**Re: McMahon Market Place Lots 9B, 9C, & 9D - 5760 McMahon Blvd NW
Erosion and Sediment Control Plan
Engineer's Stamp Date 11/28/2022 (A11E011I)**

Based upon the information provided in your submittal received on 1/30/23, it seems that you still intend to split the site into two areas of control, and you have provided a plan for lot 9B only. The above-referenced ESC Plan cannot be approved until you address the following comments.

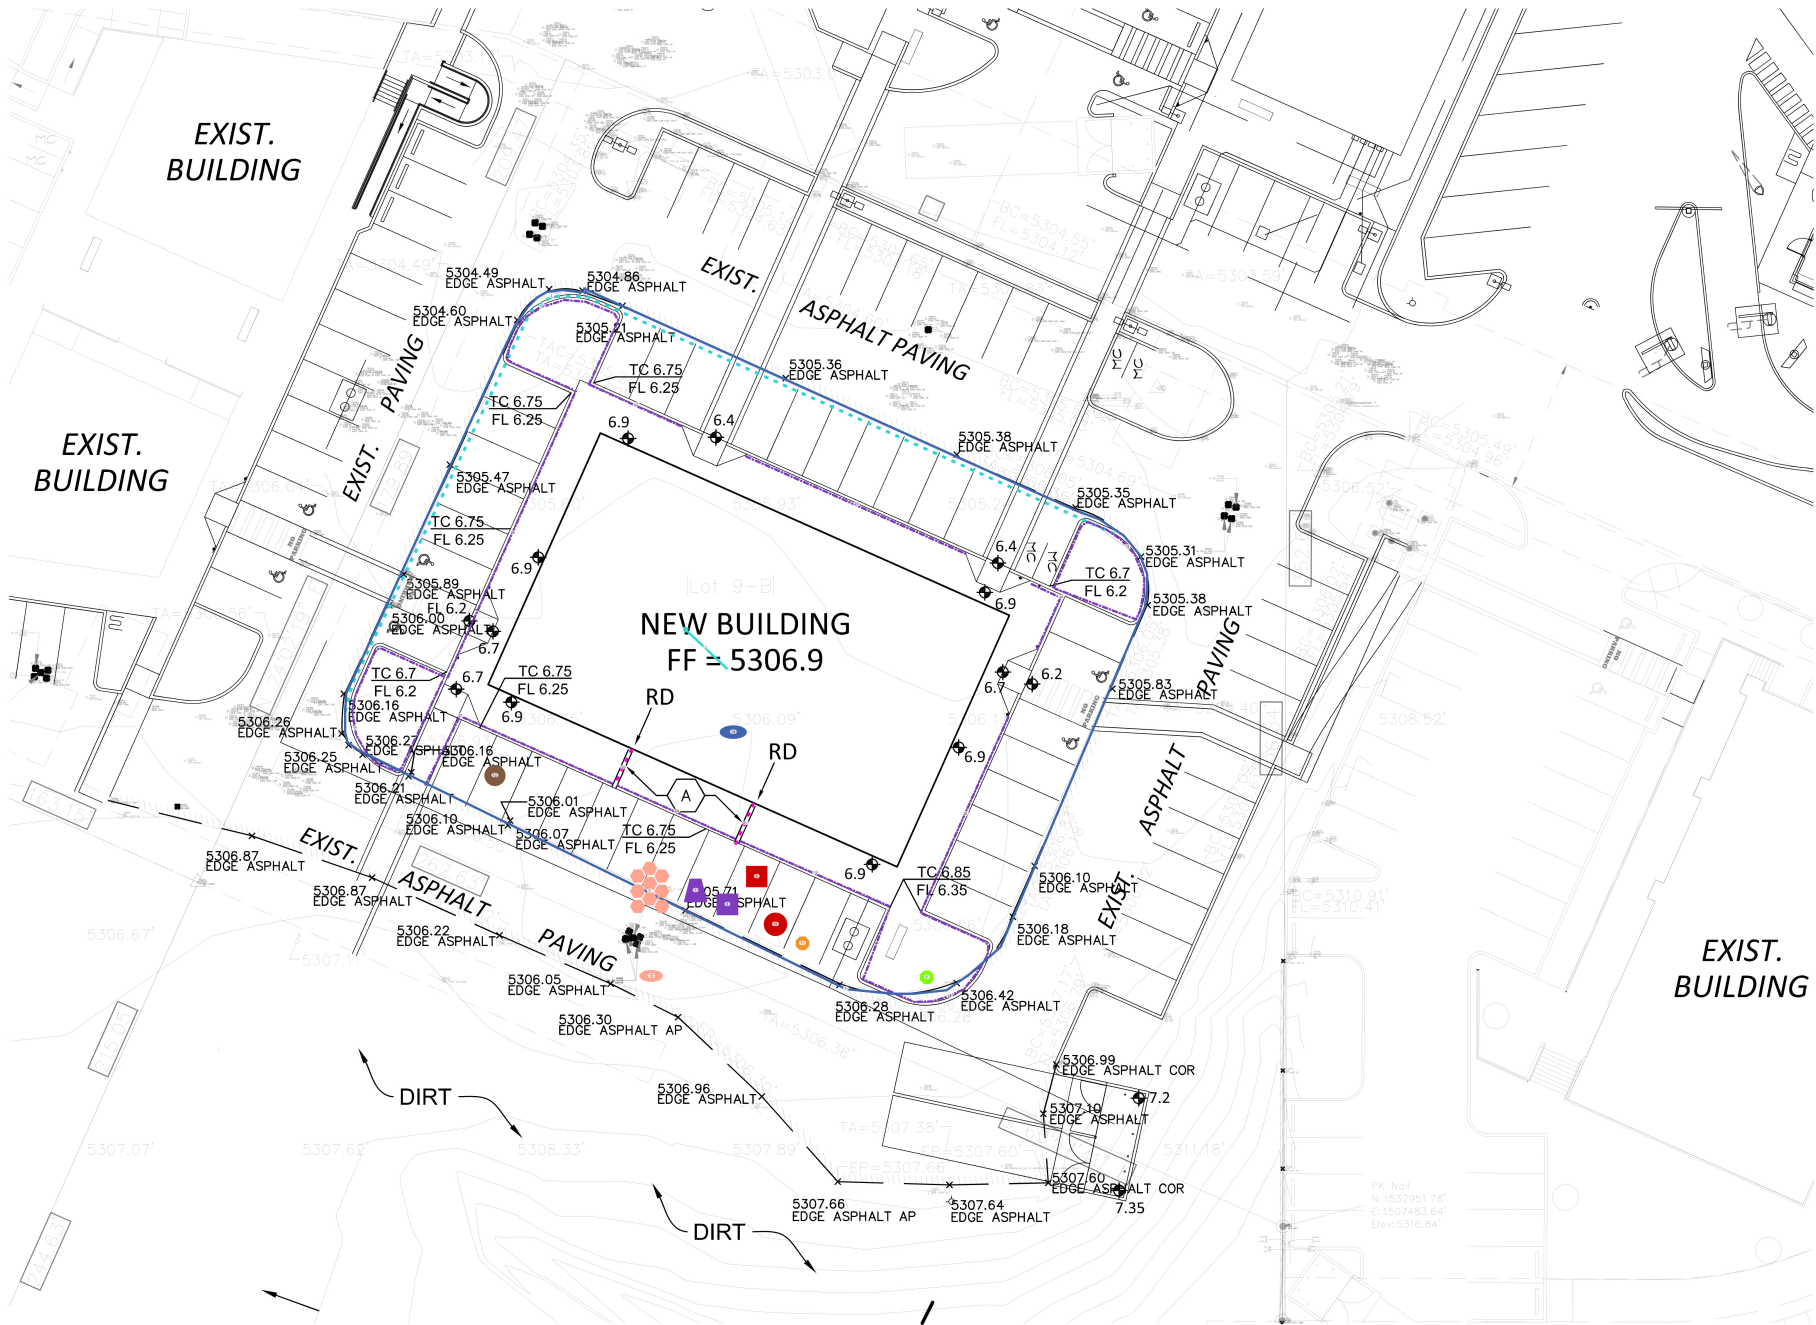
4. The legend includes a line type for the "Property Boundary /Limit of Disturbance" but the property boundary & limit of disturbance are at different locations on the site and the property boundaries are not accurately shown on the ESC Plan. Show the lot lines accurately using a different line type and label the lot numbers on the ESC Plan.

5. Add inlet protection at all of the inlets that this site drains to. Show storm drains and direction of surface flow.
6. The SWPPP must include site-specific interim and permanent stabilization per CGP 9.4.1.c.i. The Landscape Plan can be used to satisfy this requirement and should be submitted separate from the ESC Plan with the application to the Stormwater Quality Section of the Planning Department and they should be included in the SWPPP. Provide a specification on the ESC Plan for any disturbed areas not covered by the Landscape Plan.

7. Describe the nature and extent of construction activities (CGP 7.2.2.). Include the size of the property, and the size of the area of land disturbing activities. The estimated area to be disturbed, 8.39 acres, on sheet 2 seems excessive. It should be noted that the lot area, 0.92 acres, shown on sheet 4 is part of a 10 acre Common Plan of Development or Sale.
